From: [Haley Mercer](#)
To: ["Chris Cruse"; Justin Turnbull](#)
Cc: [Zach Torrance-Smith](#)
Subject: RE: BL-24-00001 Sligmann
Date: Wednesday, February 21, 2024 11:43:17 AM
Attachments: [2002-16243.pdf](#)
[2016-0488.pdf](#)
[4025_001.pdf](#)
[4030_001.pdf](#)
[B15-P095.tif](#)
[exhibit.pdf](#)

Chris,
In reviewing the Sligmann BLA, we have encountered a bit of a snag. Kittitas Compass GIS shows a County owned parcel (APN:077834) located within the area proposed as Parcel A.

Drawing file: BL-24-00001 Sligmann / BL-24-00001 Sligmann - Survey 2132024.pdf

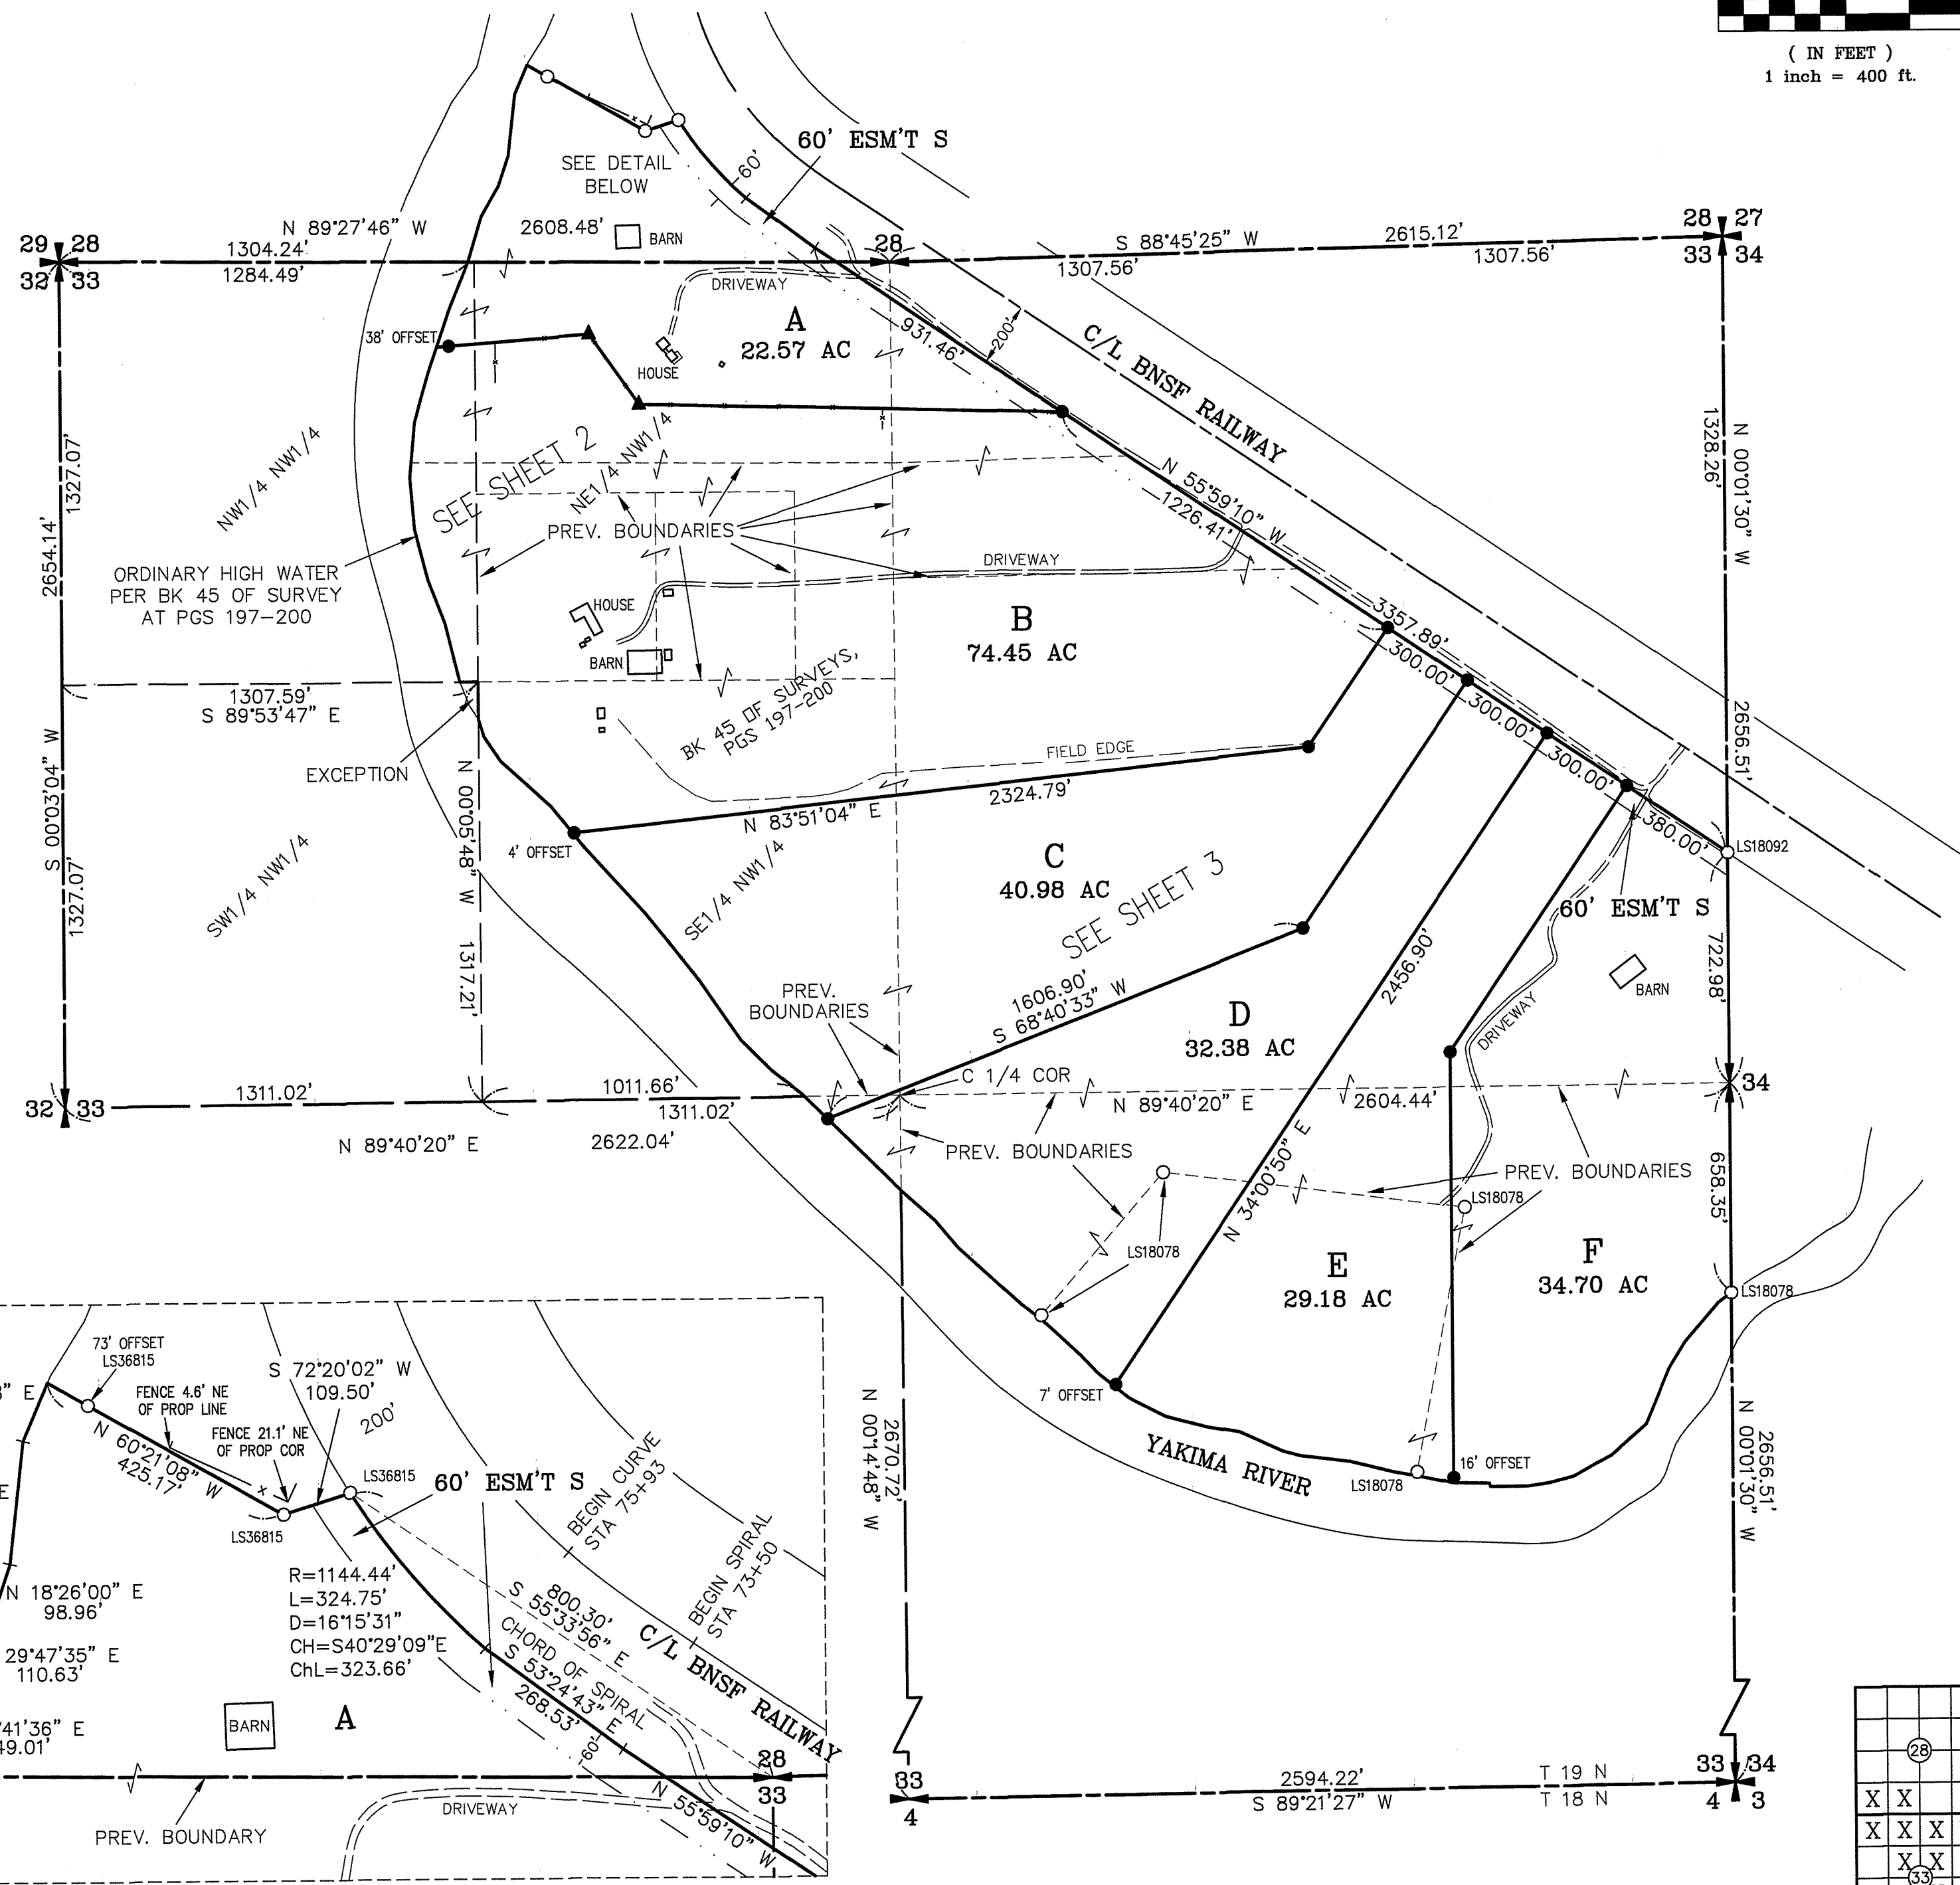
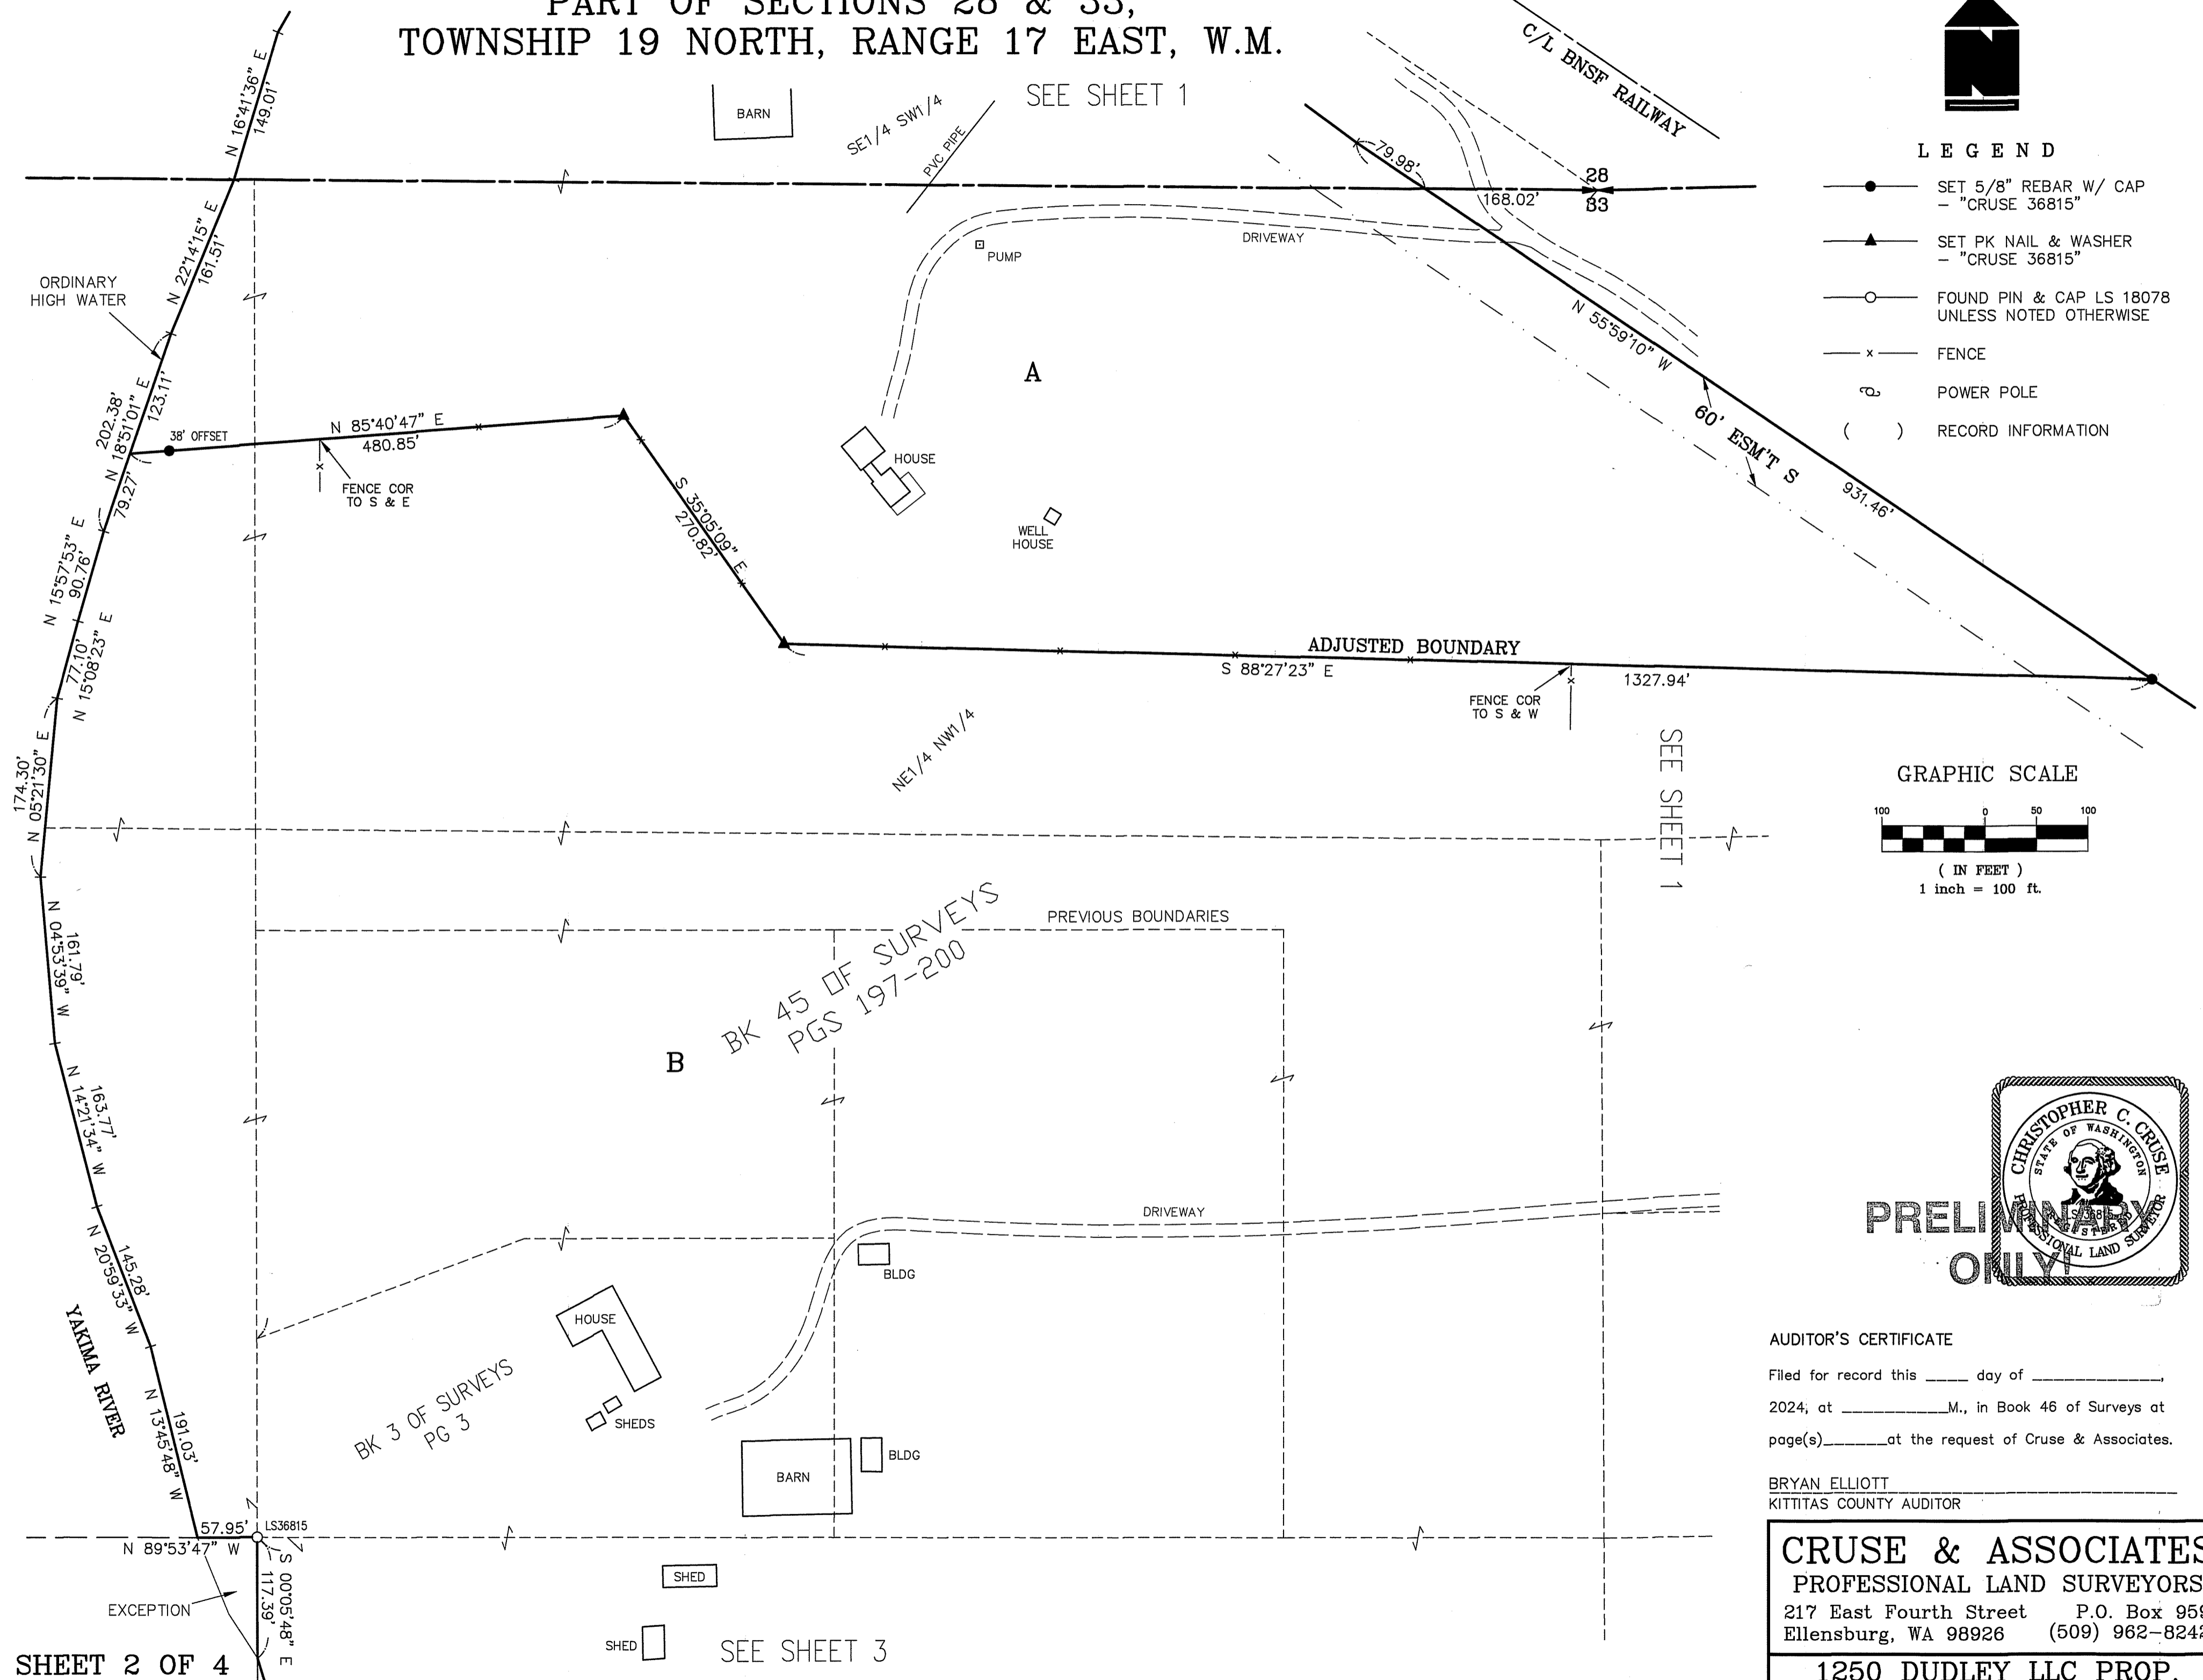
Chris,
I believe this resolves things. While not a requirement, making a note on the face of the survey similar to the note on the prior survey would be a benefit to the public record, and hopefully this whole process isn't repeated next time development happens with this parcel.

Justin - I was not planning on mentioning it on the survey as the descriptions in the title reports for these properties no longer reference an exception for TPN 077834 as apparently it was determined to not affect them.

Haley – Please let me know if the COMPAS mapping is being updated to move TPN 077834 into the r/w. I still may add a note to address if the illustrated tax parcel boundary appears to fall within this 1250 Dudley LLC ownership .
